Our ref: Modification 1 - Basement and Construction Hours – Five Ways, Crows Nest (SSD-66826207-Mod-1)

Subject: Request for Additional Information – Modification 1 - Basement and Construction Hours – Five Ways, Crows Nest (SSD-66826207-Mod-1)

BASEMENT 5
& BELOW

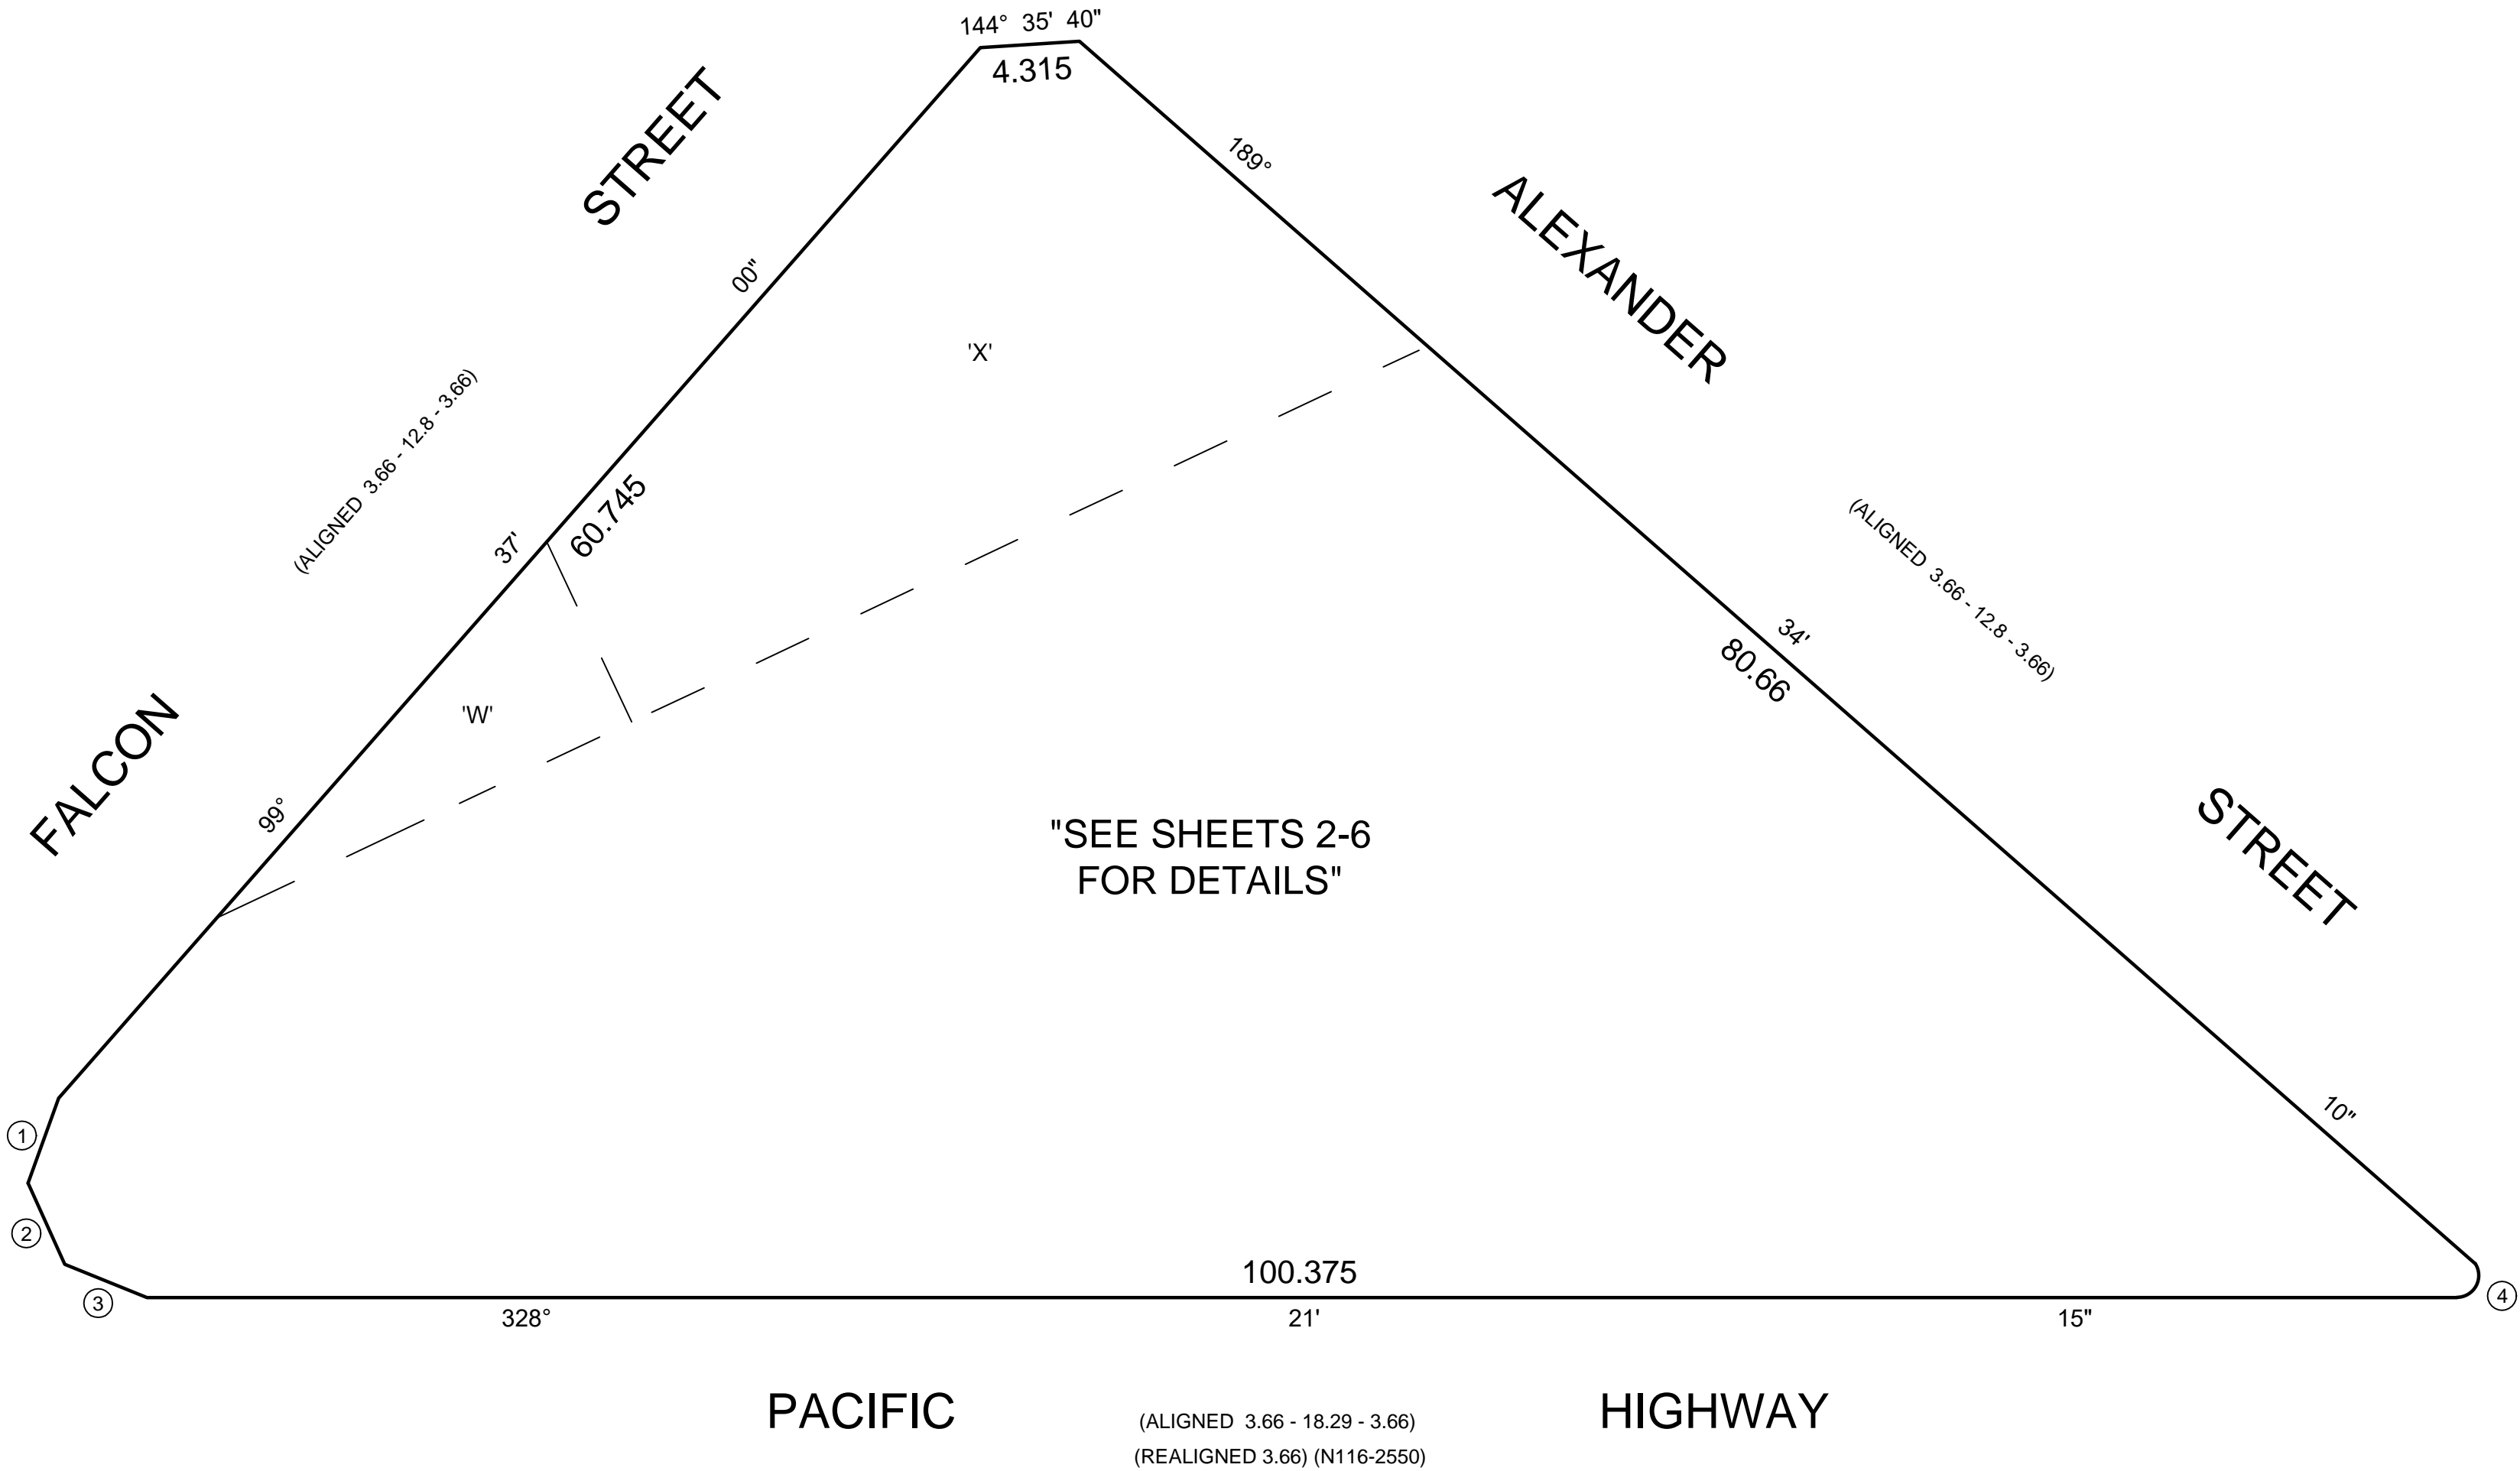
5. Provide an amended set of Stratum Plans to include the extent of RLs proposed below Basement 5 and ensure all structures below Basement 5 are captured (excluding Sydney Metro corridor).
